From: Elliott Weston <Elliott.Weston@shoalhaven.nsw.gov.au>
Sent: Thursday, 19 November 2020 5:29 PM
To: Lillian Charlesworth; Cathy Bern
Cc: Michelle Niles
Subject: HPE CM: RE: Interim response to Lillian Charlesworth - DPI - Mod to Vincentia Coastal Village PA (MP 06_0025 MOD 8) - Council's reference 3A08/1006-08 - Document D20/491393 - request to extend time to comment

I note that the applicant has provided DPIE with a letter titled *Response to submissions* prepared by Higgins Planning dated 2 November 2020 (Letter) and amended plan titled *Landscape Architectural Plan* prepared by 1710_e Dwg No. L_103 issue E dated 31 October 2020 (Landscape Plan).

Figure 5 | Proposed infill landscaping (Source: Mod 8 submission documents)

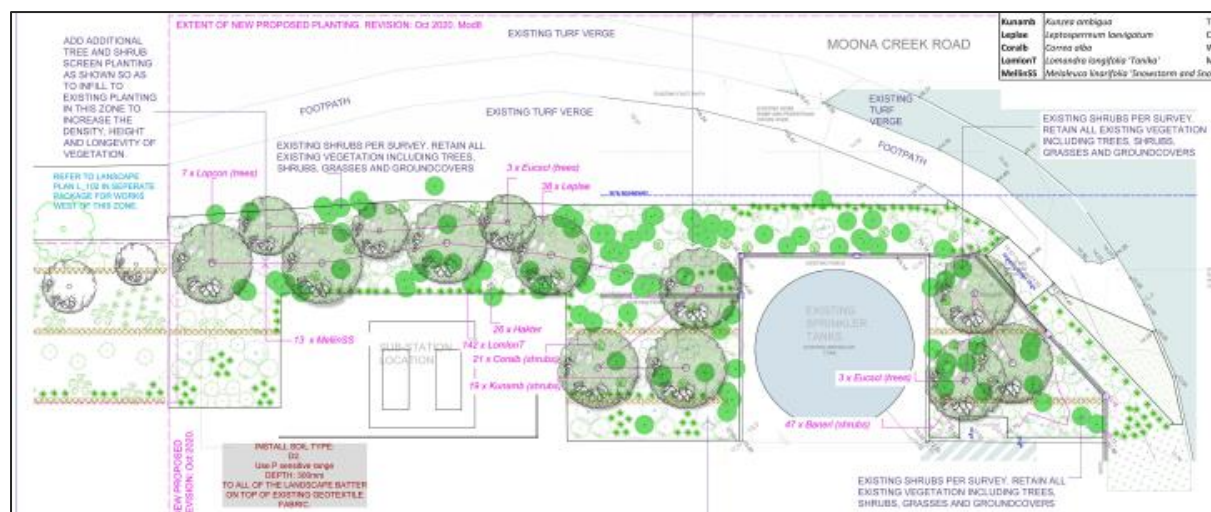
Council welcomes the removal of the signage and structures, however, it would appear that the Landscape Plan has removed the previously proposed trees (13) identified on Revision C of the Landscape Plan. This is not considered to be a positive alteration to the previous Landscape Plan.

Should DPIE be of the view to approve the modification application, Council would encourage consideration of a condition or amended plans that would require the 13 tree plantings identified on Revision C of the Landscape Plan to be identified on the final plans for approval. The previously identified species are considered appropriate.
